RE: **Grading and Drainage Certification**
Beck Office Systems (Oakland Avenue)
(C-18/D037C)
Engineer's Stamp dated 3/3/2000
Engineering Certification dated 9/30/2000

RE: ENGINEER'S CERTIFICATION FOR BECK OFFICE SYSTEMS
OFFICE/WAREHOUSE, OAKLAND AVENUE (C-18/ D037C), ENGINEER'S STAMP
DATED 3/3/00, CERTIFICATION DATED 9/30/00.

RE: *BECK OFFICE SYSTEMS (C18-D37C). GRADING AND DRAINAGE PLAN FOR SITE DEVELOPMENT PLAN FOR BUILDING PERMIT, AND FOR BUILDING PERMIT AND SO#19 PERMIT APPROVALS. ENGINEER'S STAMP DATED MARCH 3, 2000.*

SHEET
C-1

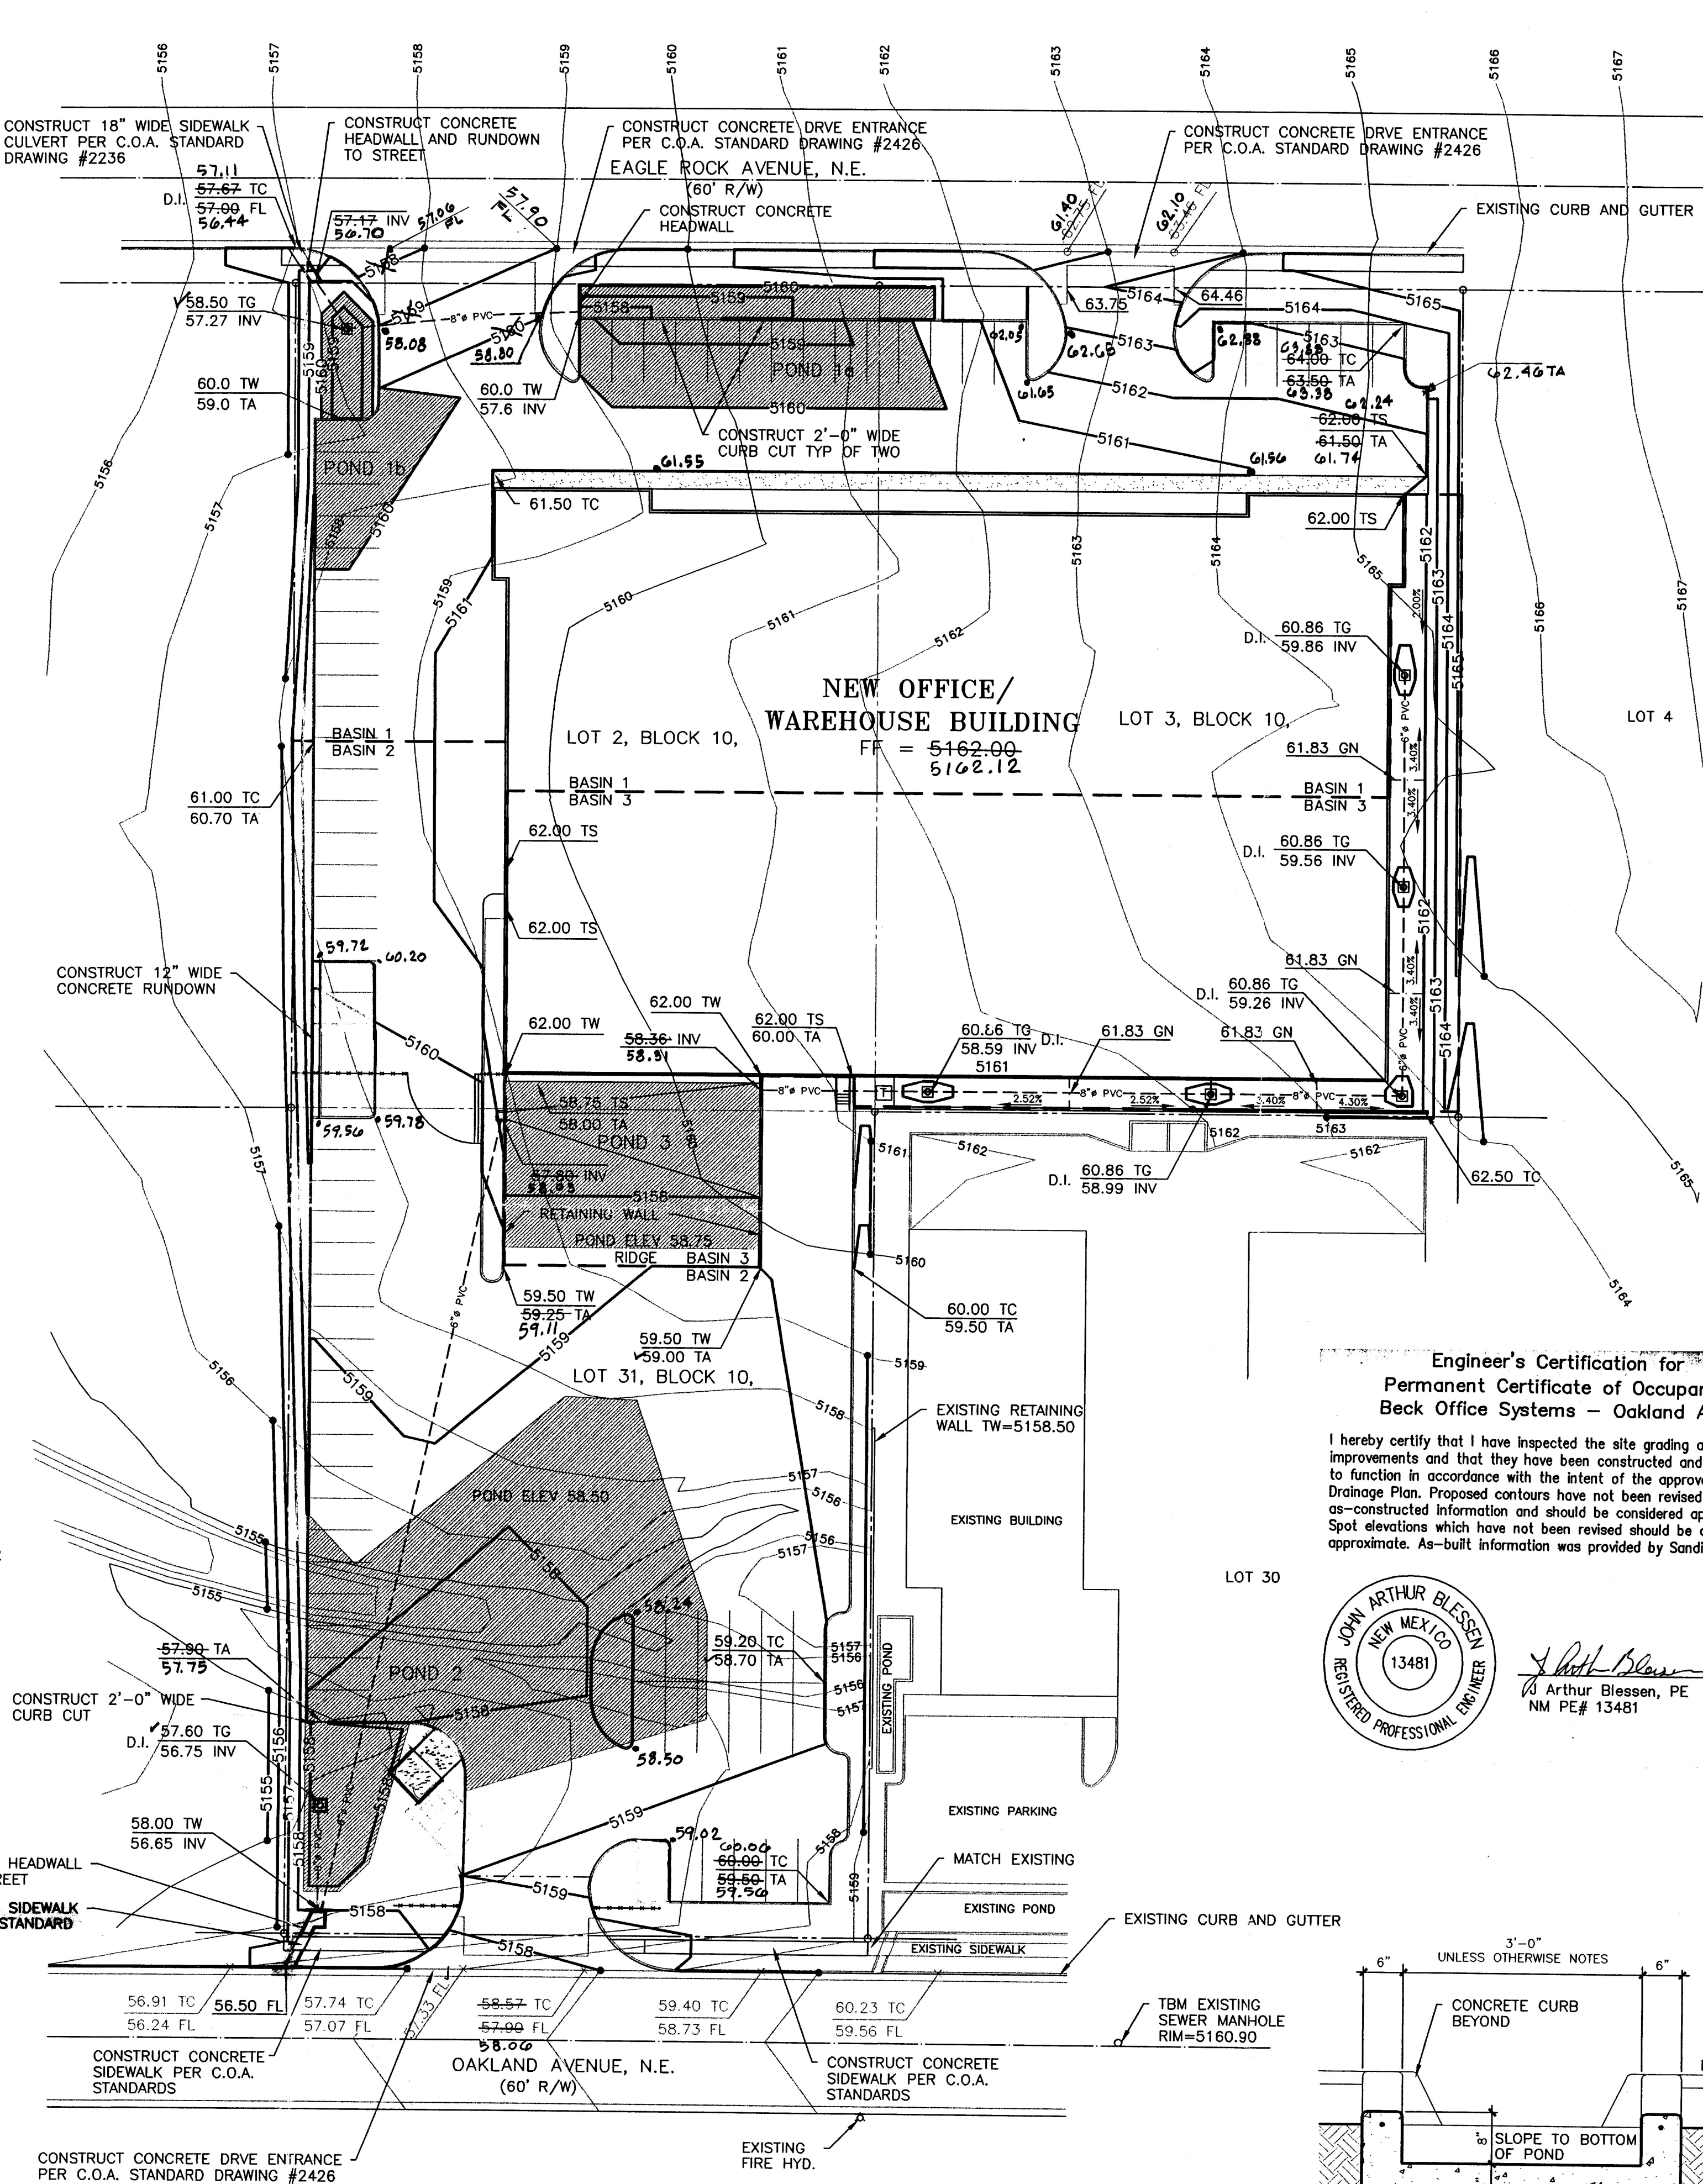
N Add the standard notes and signature block for the SO#19 to the G&D Plan so that the Building and SO#19 permits can be approved. Furnish a second set for the SO#19 process.

Leave the Site Plan as Sheet C-1 and renumber the G&D Plan as Sheet C-2.

Transportation reviews the T.C.L, (Site Plan) separately. The approved Site and G&D Plans must agree. That portion of the FIRM showing flood hazard areas should be included (like the Vicinity Map) on Sheet C-2.

Spoke with Art
(FONCON) for need
to elaborate on
outlet controls
for ponds. JH
